Response to TOA Comments – 23–31 Dover Road, Rose Bay

We are writing on behalf of Dover Street (Rose Bay) Developments Pty Limited (**the proponent**) in respect of the State Significant Development application (**SSDA**) (SSD- 86017721) for an in-fill affordable housing development at 23–31 Dover Road, Rose Bay (**the project**).

This information is submitted in response to the Request for Additional Information (**RFI**) issued by the Department of Planning, Housing and Infrastructure (**DPHI**) via email on 11 March 2026.

- ROUTE FROM INDIVIDUAL UNIT TO GARBAGE CHUTE & BIN STORE ON SAME LEVEL
- ROUTE FOR PRIVATE CONTRACTOR TO TRANSFER BINS AND BULKY WASTE FROM BASEMENT WASTE & BULKY WASTE STORES TO COLLECTION POINT

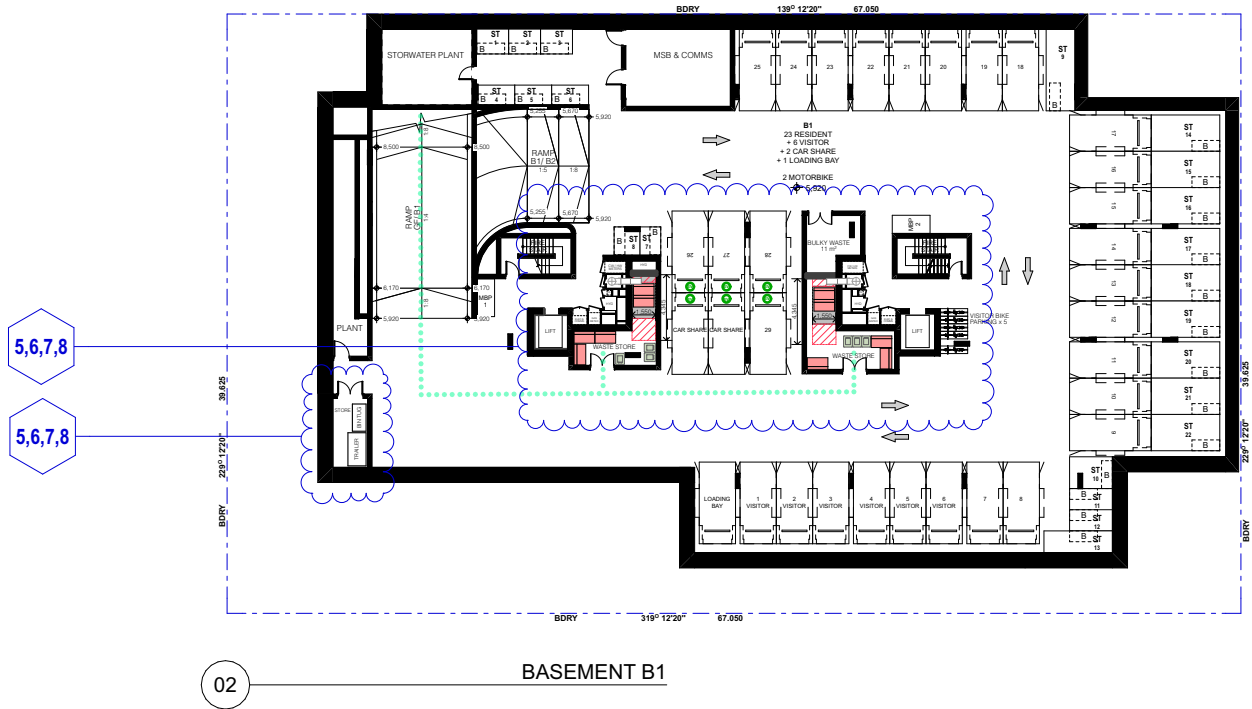
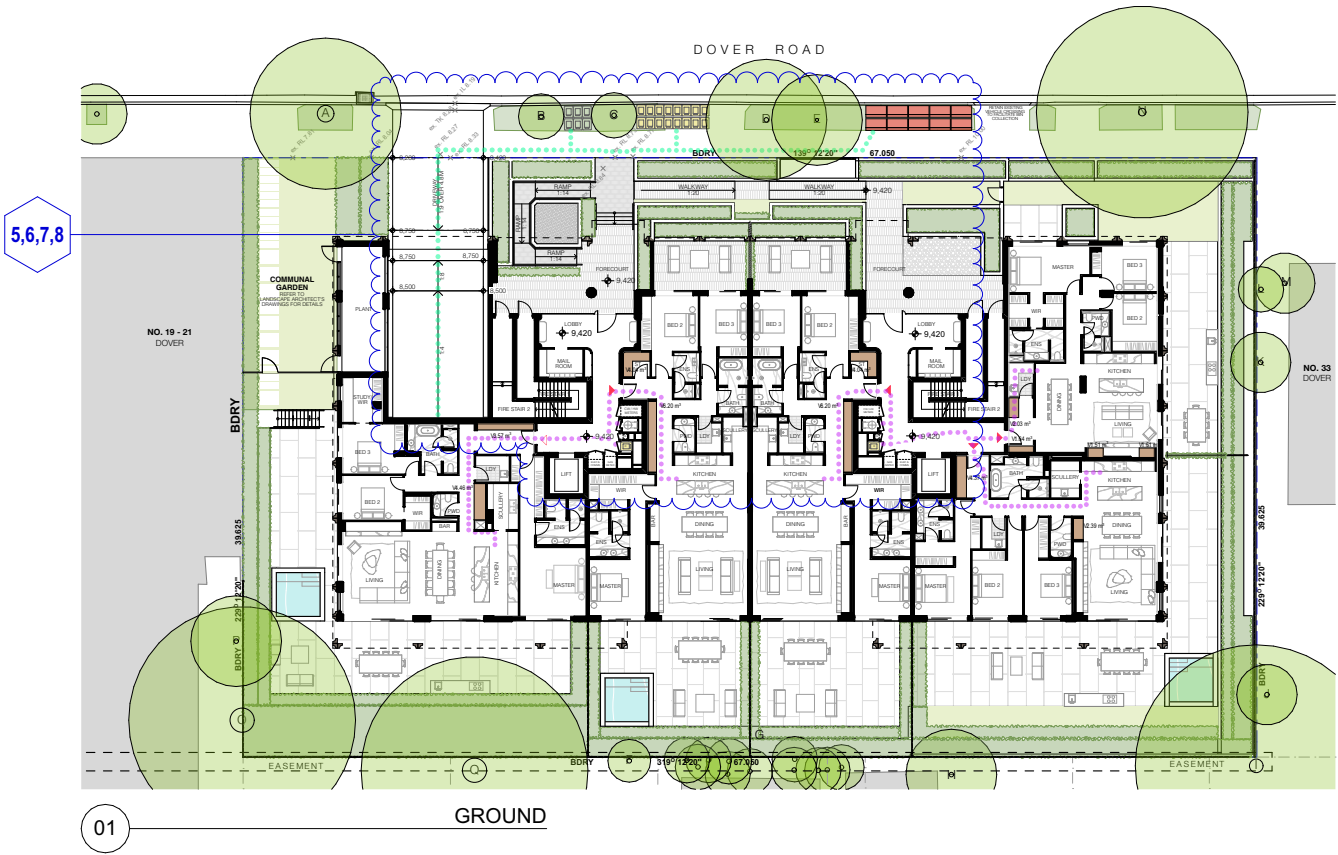
5. A bin tug vehicle is now proposed to be stored within the basement as an alternative waste collection strategy , please clarify the proposed storage area on the plans.	The waste storage area is identified on the Architectural Plans.

7. DA9106 illustrates routes for private contractor to bin storage for collection still going through the lobbies and Appendix N states that this strategy will not change. Please clarify whether the route going via the lobbies will be used for waste collection? Subsequently remove routes that go through the lobby areas from the architectural plans, as this will remove any ambiguity on the waste travel routes.	The MRA Waste Response Statement confirms no bins or bulky waste will be transferred through the residential lobby.

6. Update the plans to also include transfer path for bulky waste.	The MRA Waste Response Statement confirms the transfer path for bulky waste will be the same as bin transfer path. The transfer of bulky waste items to the kerbside for Council cleanup will be facilitated by a small trailer used in tandem with the bin tug.

GROUND COS - SCENARIO 1

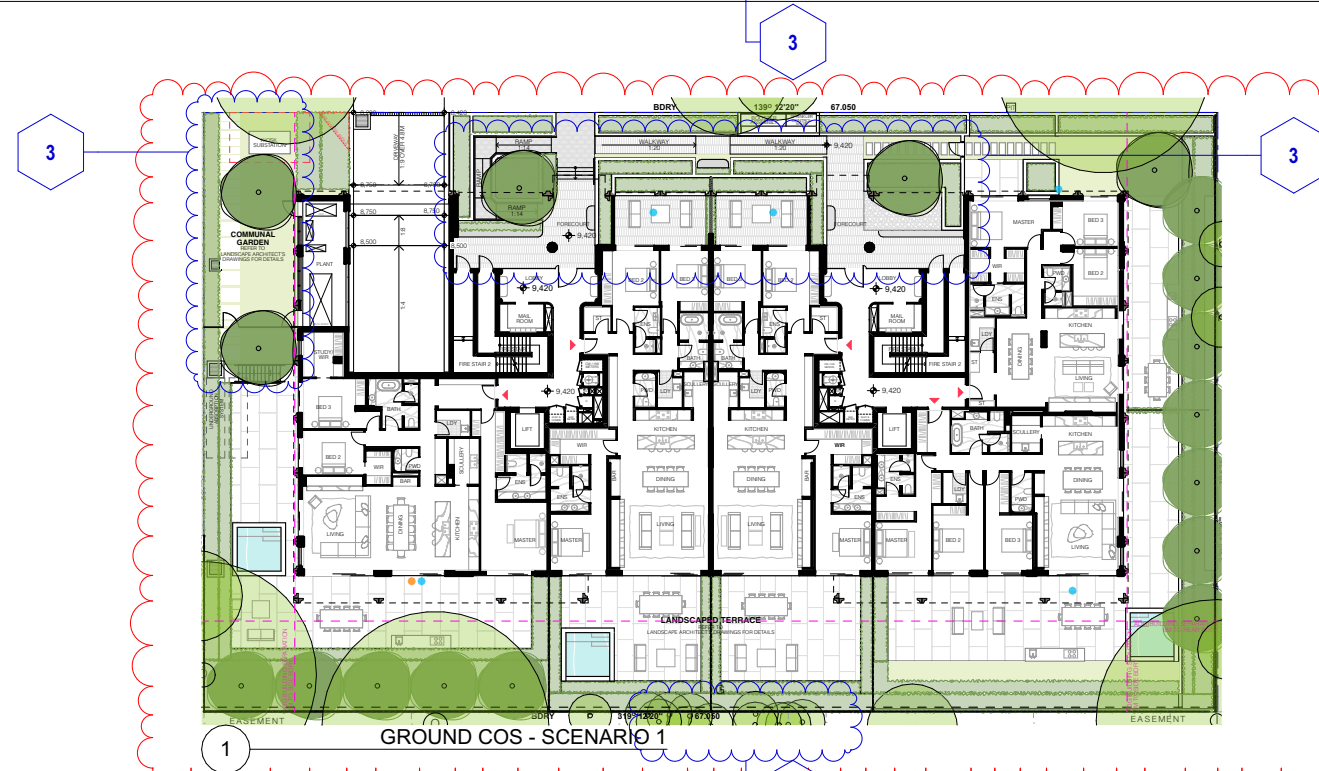
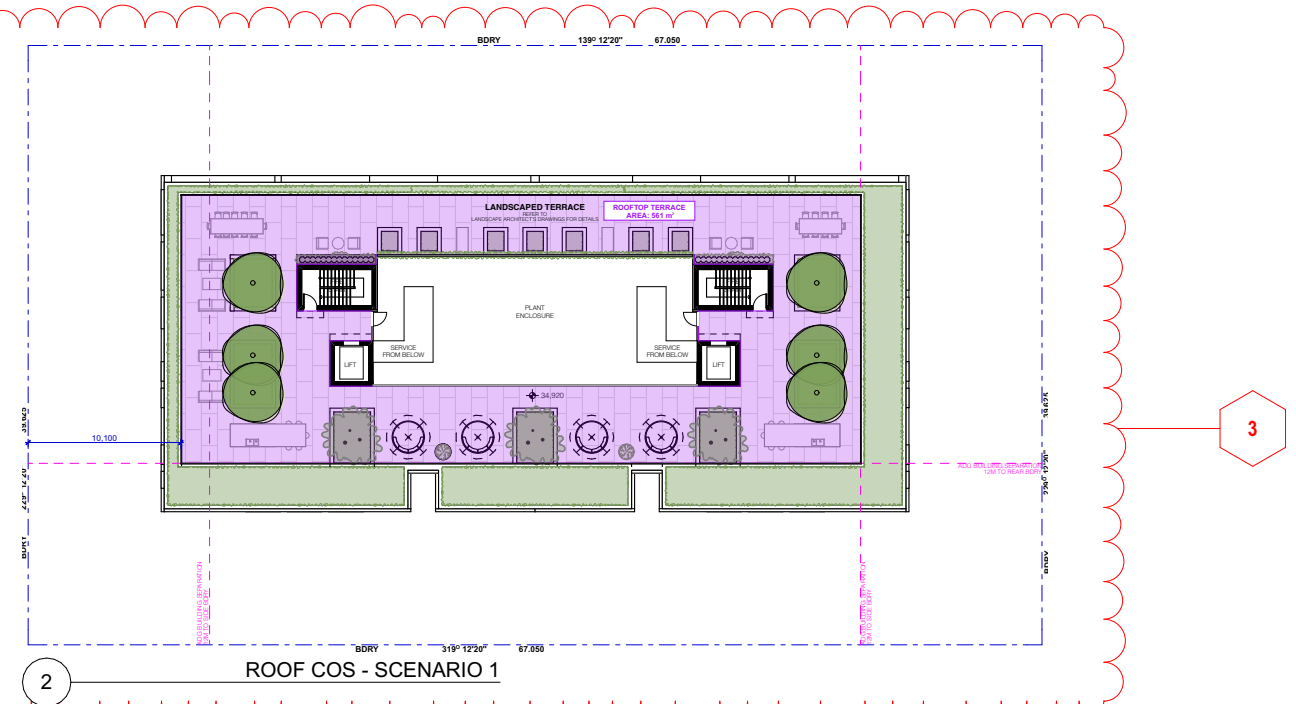
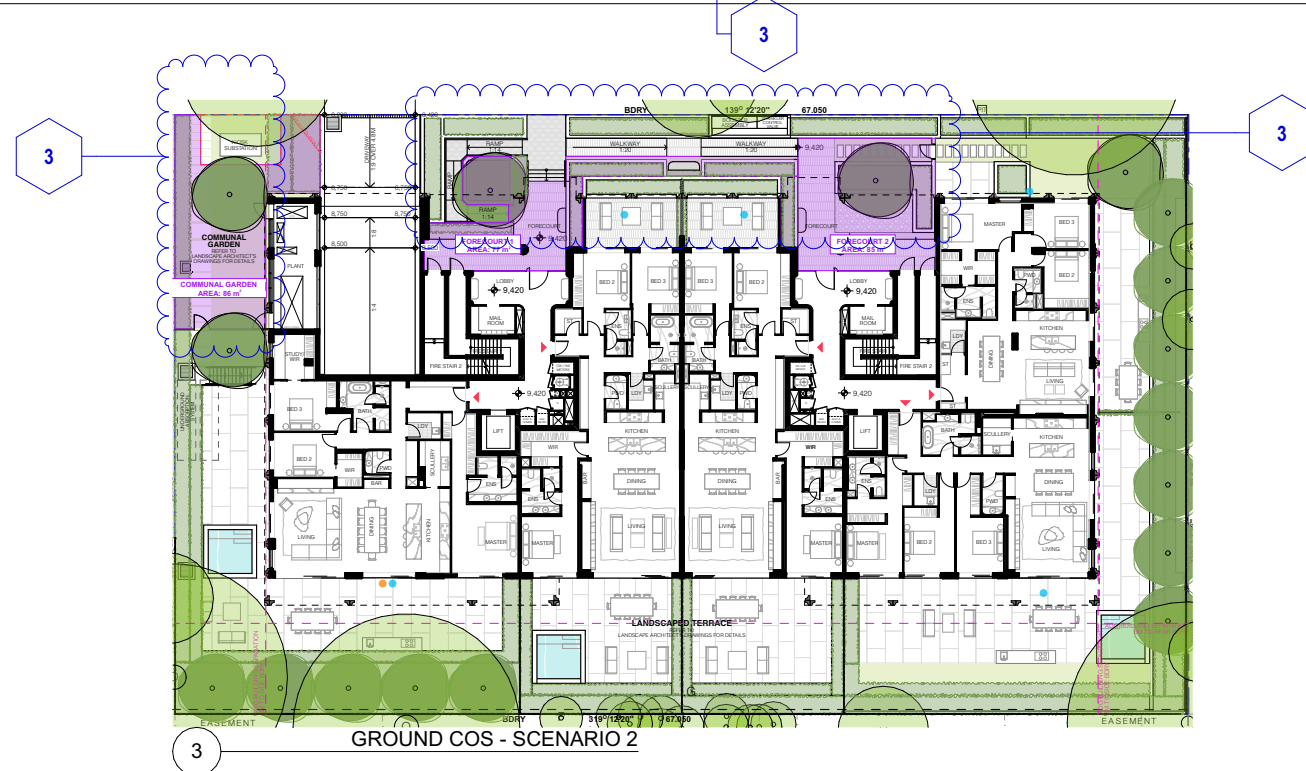
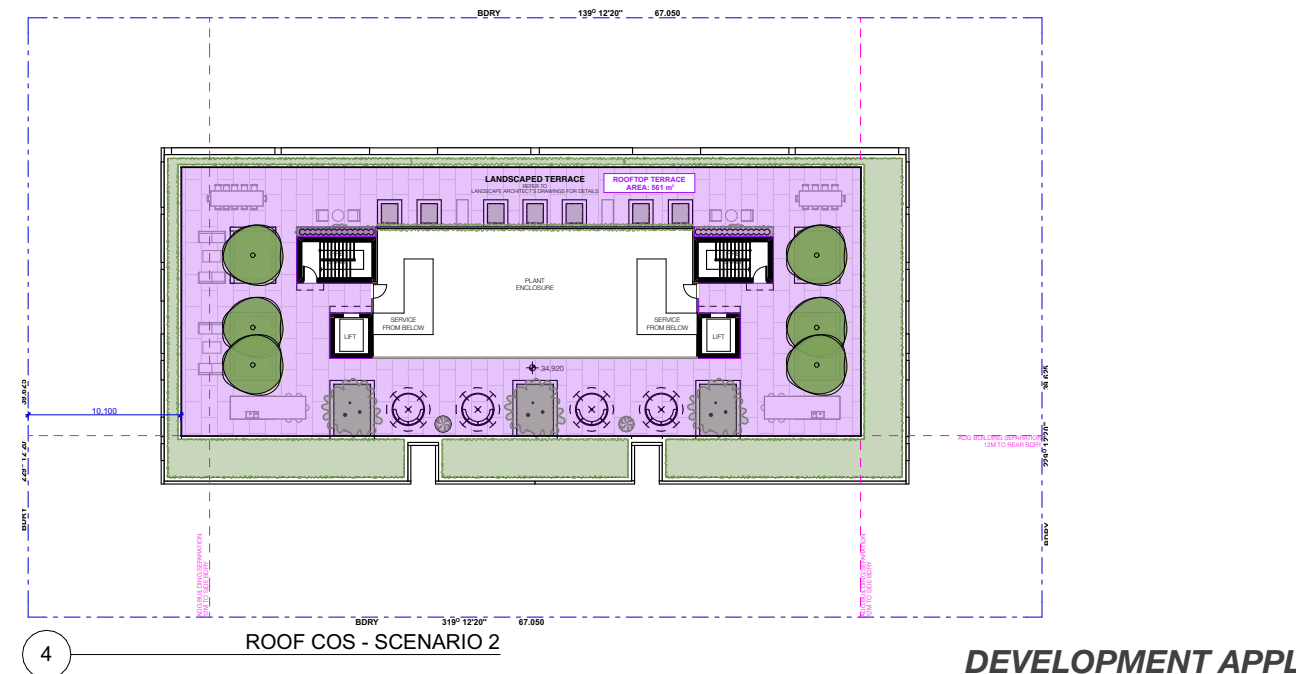
3. There is concern over access to communal garden located on the ground floor as residents have to leave the building onto the pedestrian footpath in order to access the communal garden. Please reconsider the accessibility to the communal garden.

The western garden at ground level has been retained within the scheme. Direct access from the lobby to this garden through the site is not feasible due to the site's topography and limited frontage width. Accordingly, while this area (86sqm, representing 3.2% of the site) will continue to be provided on site, it has been excluded from the formal communal open space calculation in response to the DPHI concerns regarding accessibility.

In addition to the primary rooftop communal open space (561sqm), both forecourts (162sqm, representing 6% of the site) have been redesigned to provide genuine and functional communal open space. While DPHI has advised that these areas cannot be formally counted toward the communal open space requirement, the current design iteration has significantly enhanced their usability through increased landscaping, additional seating, and dedicated lawn areas suitable for pets. These improvements support informal recreation and social interaction for residents, while also creating a high-quality transition between the buildings, communal open space areas, and the public domain.

The exclusion of the western garden and forecourts from the formal communal open space calculation results in a 4% shortfall against the 25% requirement under the ADG. This results in a reduction of communal open space from 808.4sqm (30% of the site area) to 561.32 (21% of the site area). Ultimately, if all areas were included within the communal open space calculation, there would be a significant over-provision of >30% of the site area.
